## Summary Report (v2 October 2023)

This report has been prepared to assess the details provided to discharge conditions 14, 15, 16, 17, 20, 24 and 28 for Bicester Eco Town Exemplar Site, Banbury Road, Bicester under Application Reference 21/01227/F.

**DRAWING TITLE: BICESTER ECO TOWN - PHASE 3 & 4 Roof Details - Green Roofs**

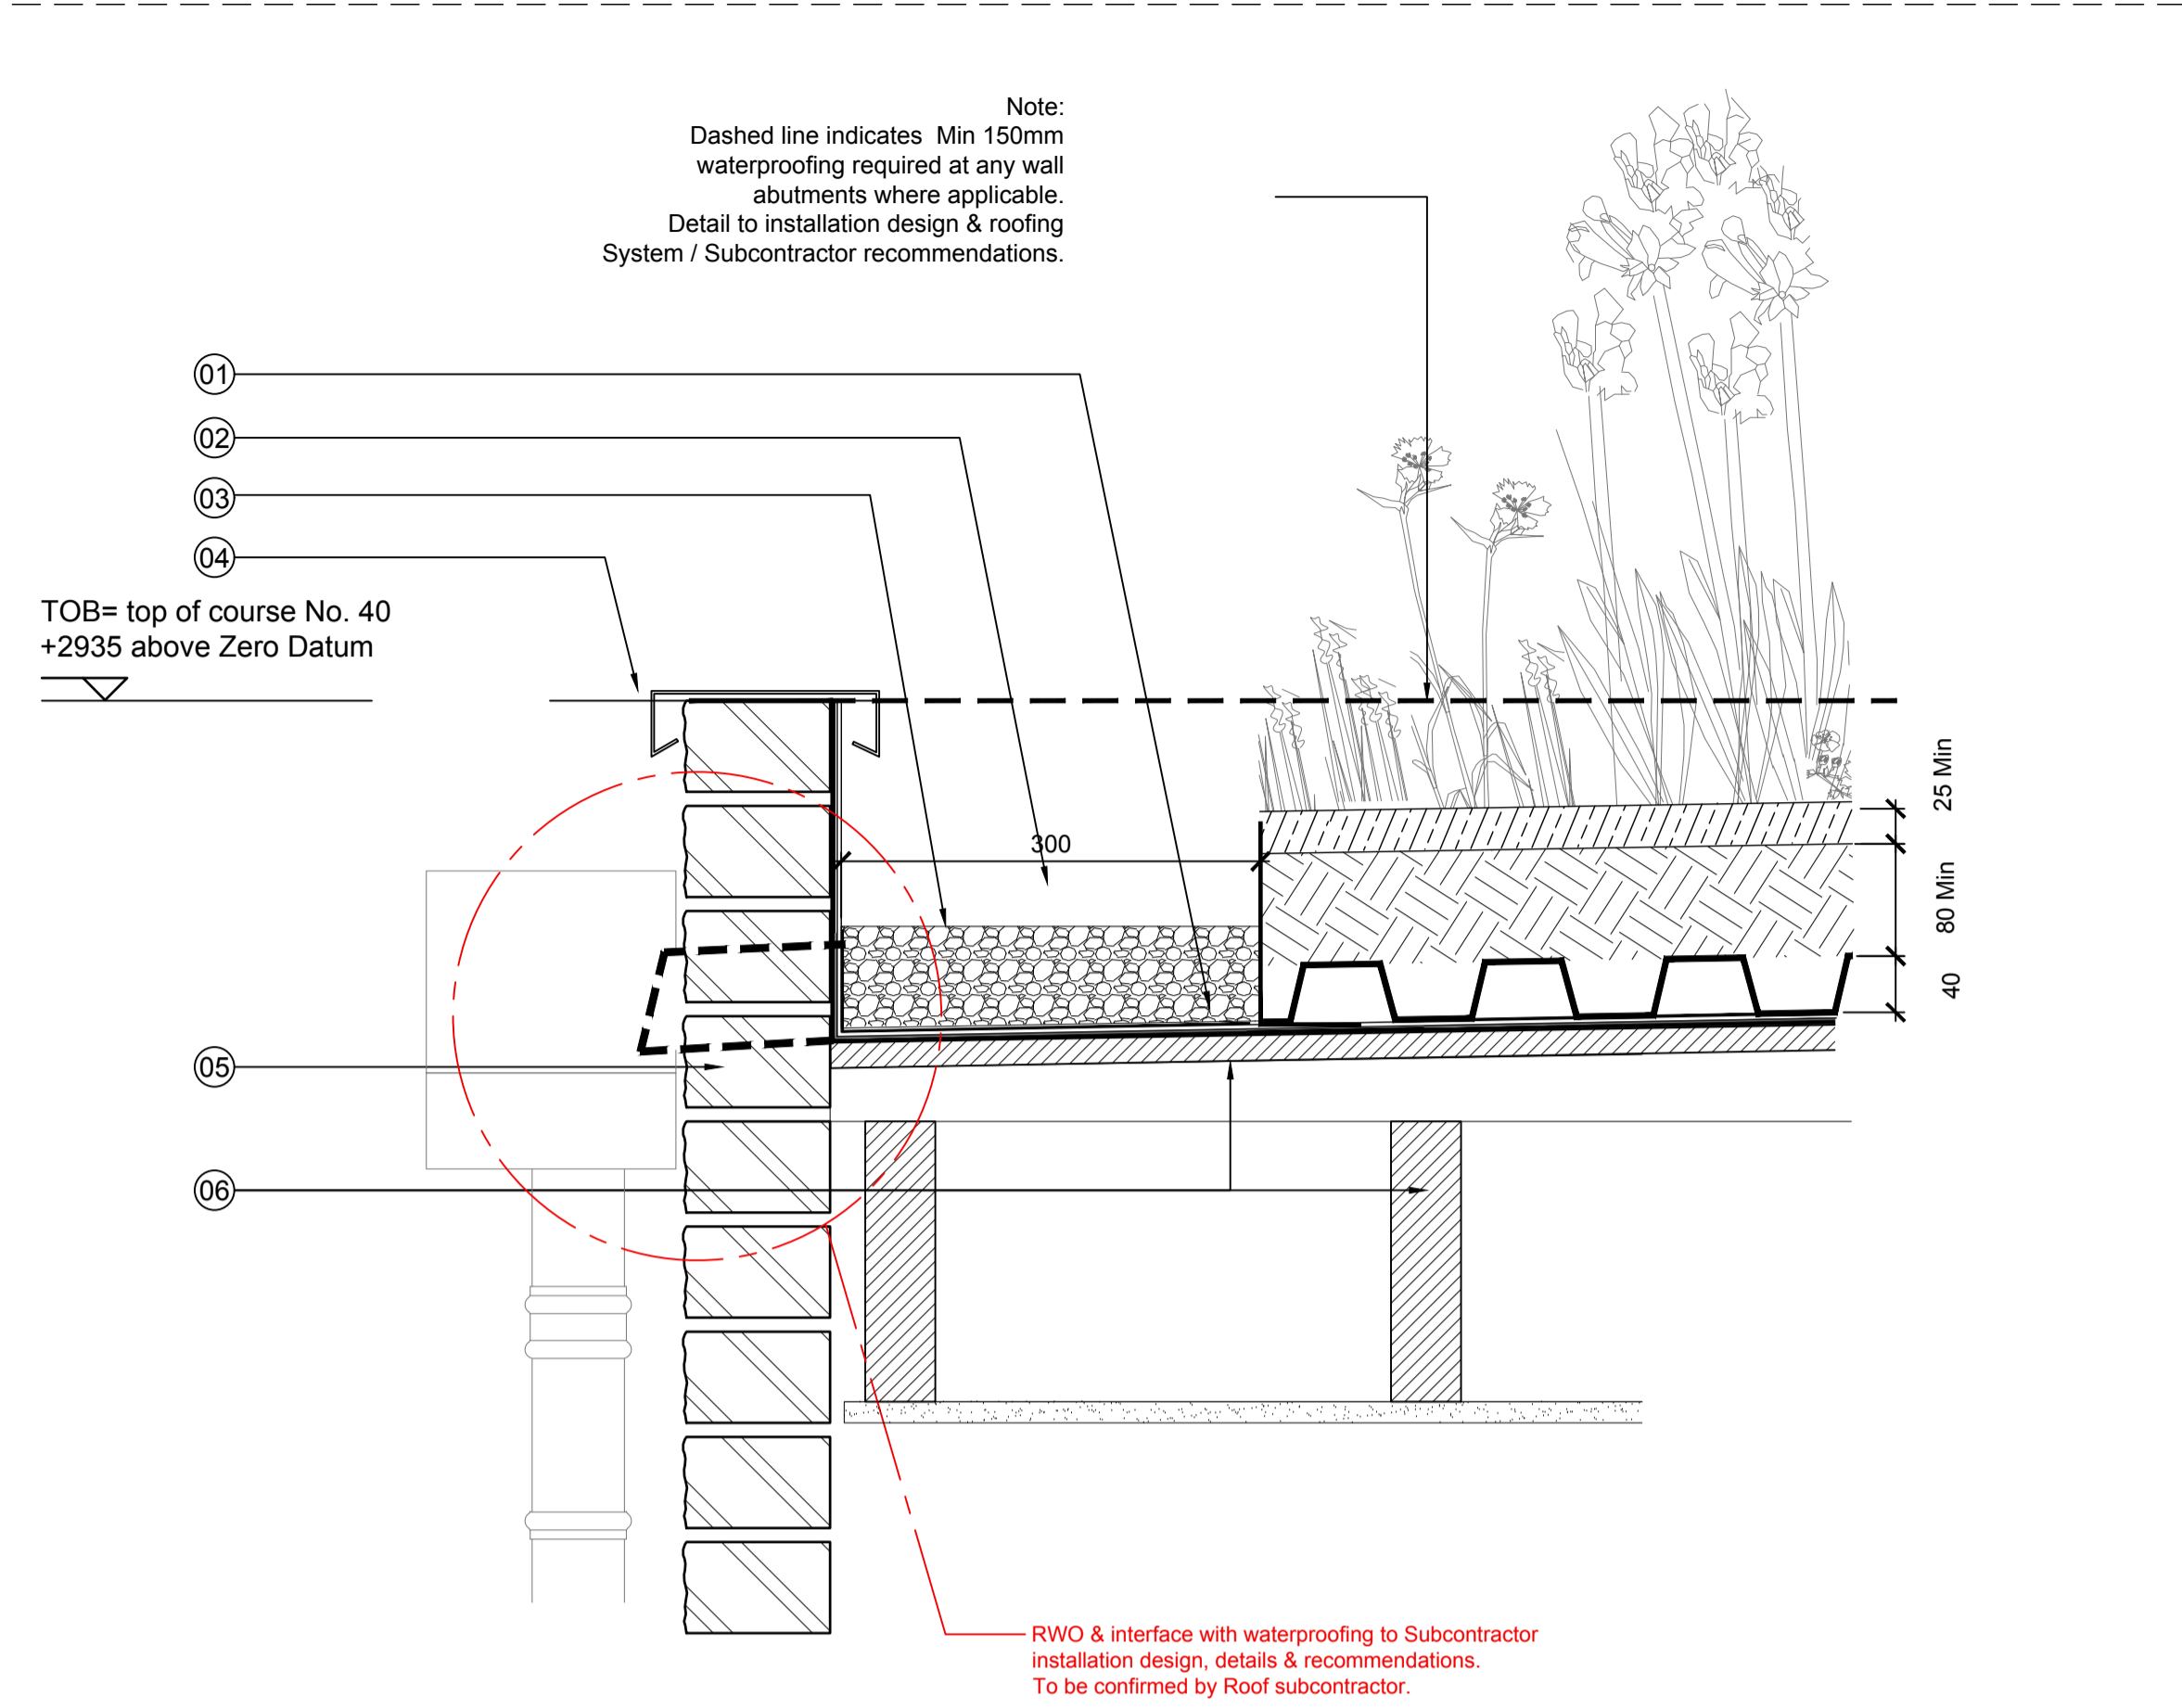
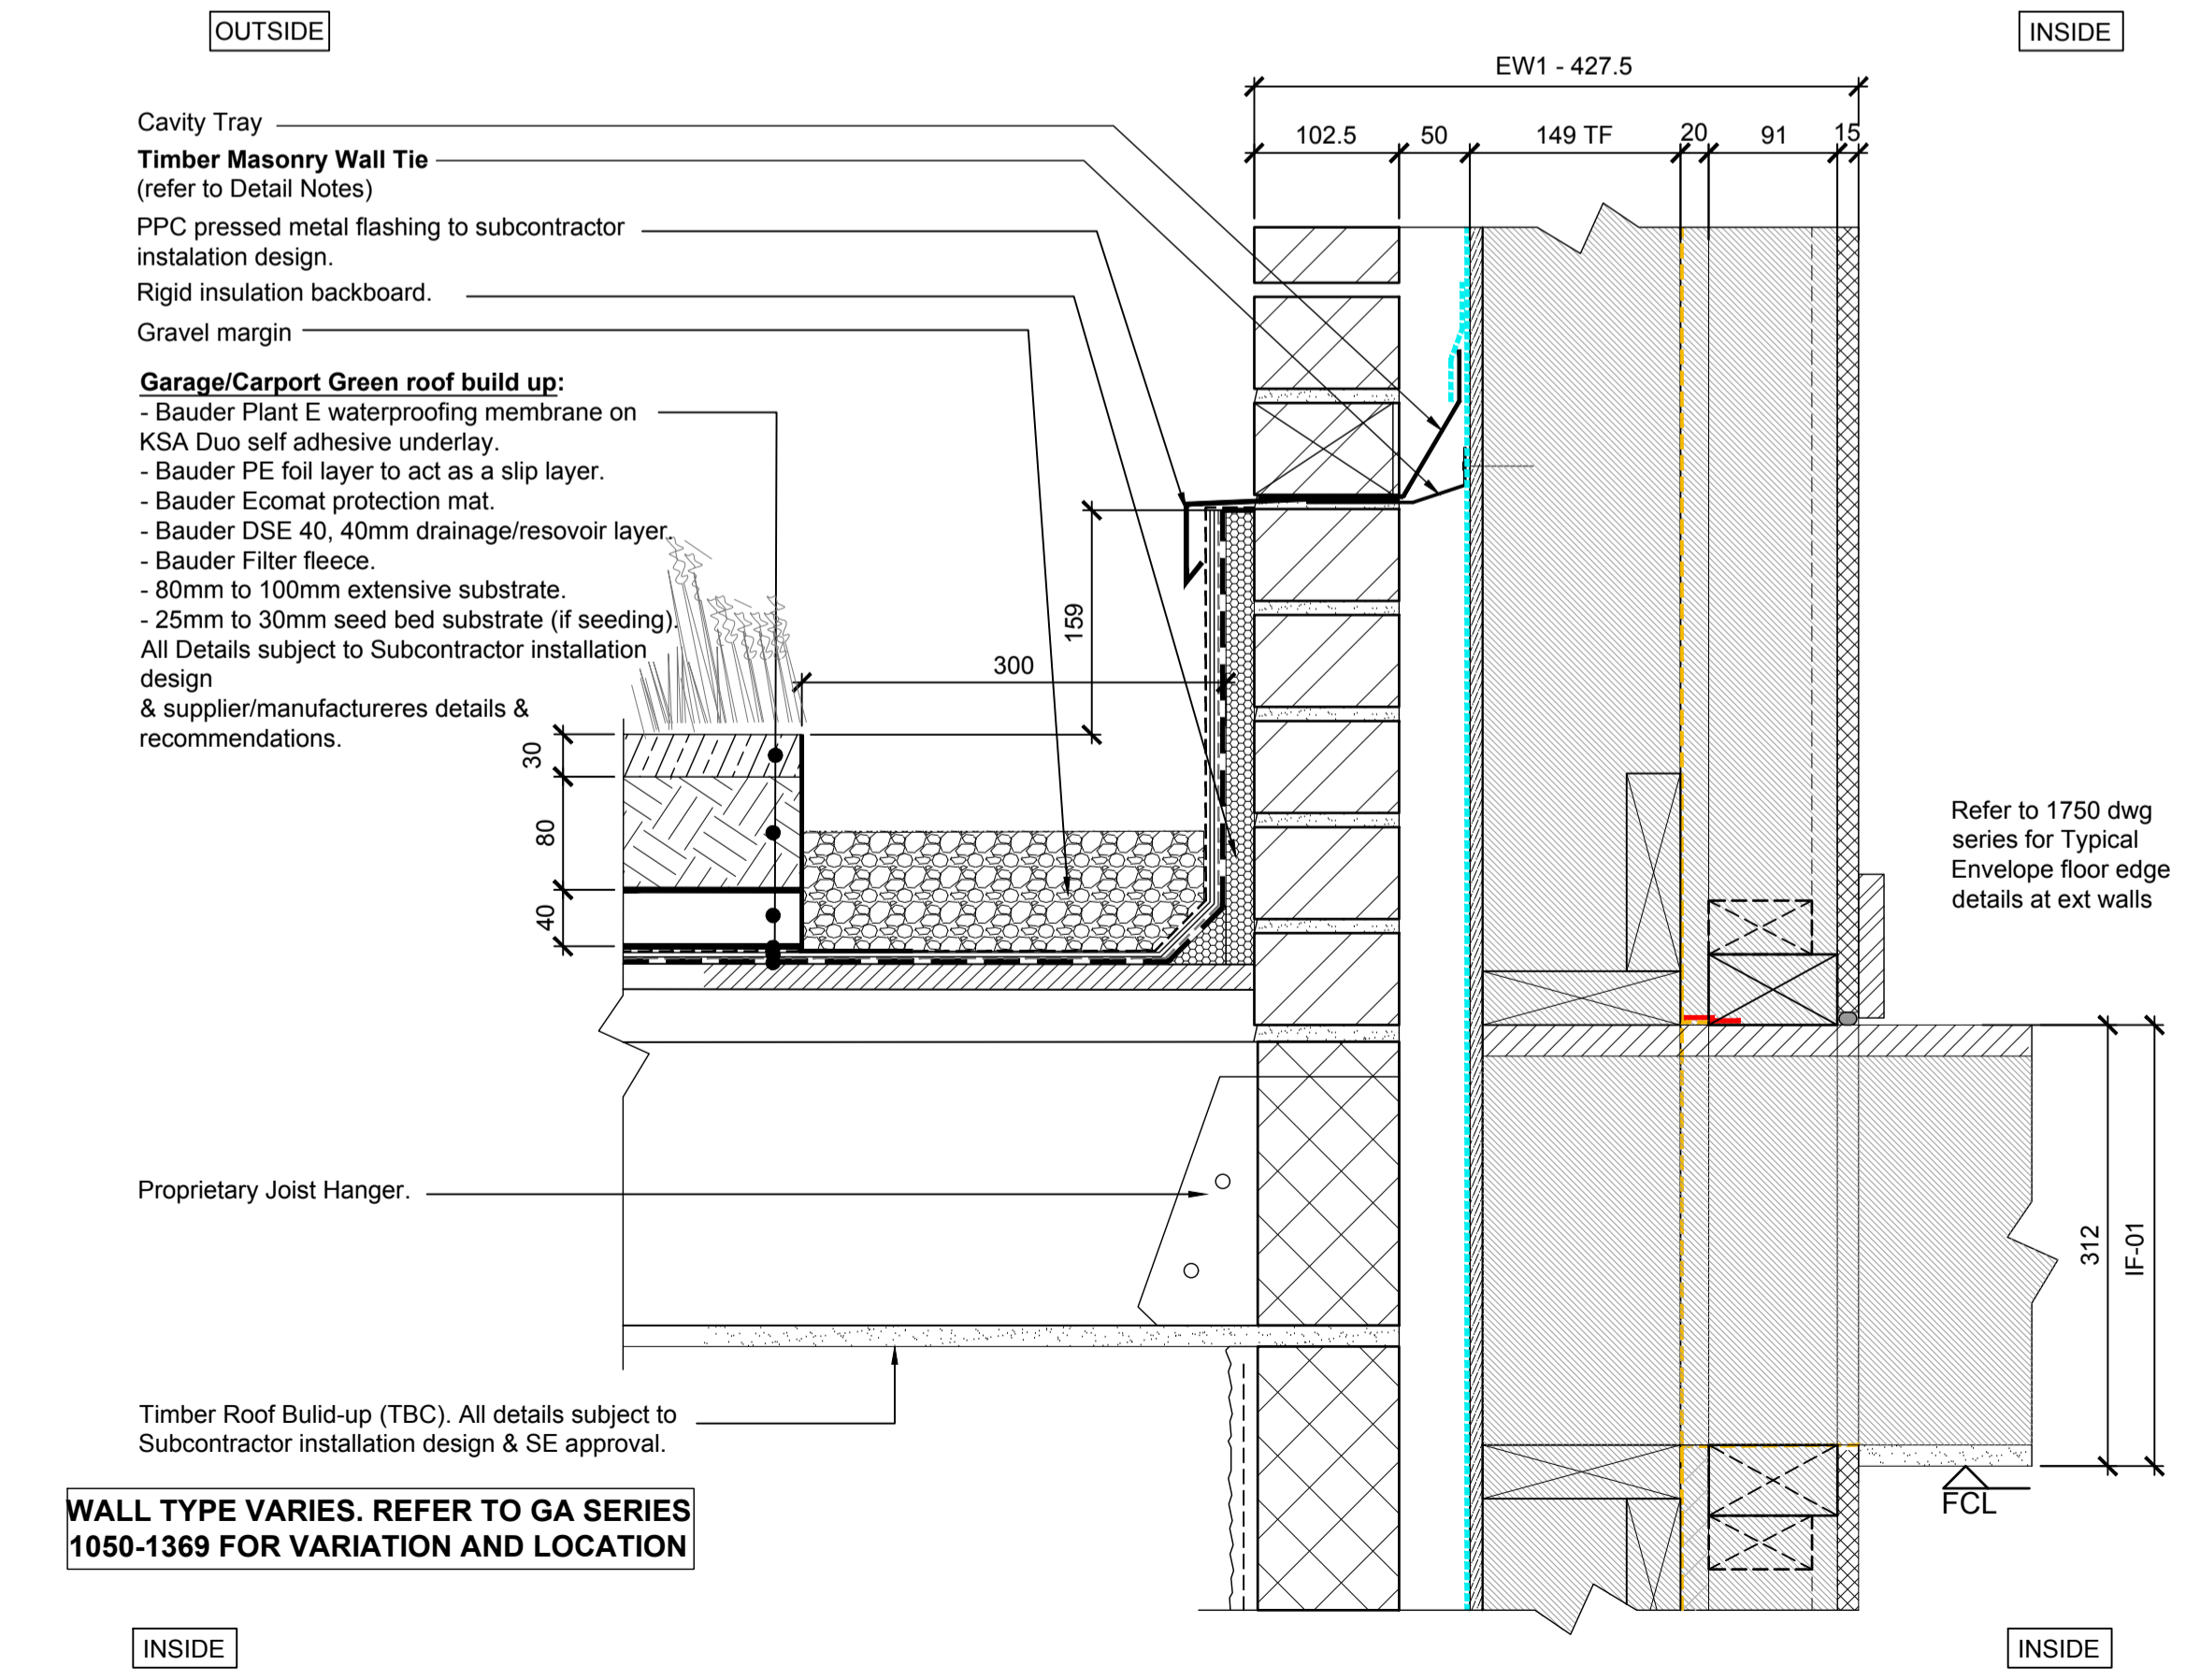
The presented maintenance programme is generic and vague. It is not a detailed maintenance programme that will ensure the delivery and long-term maintenance of the roofs.

The green roof layout plan is not provided and therefore is not possible to assess the arrangement of the green roofs within the development.
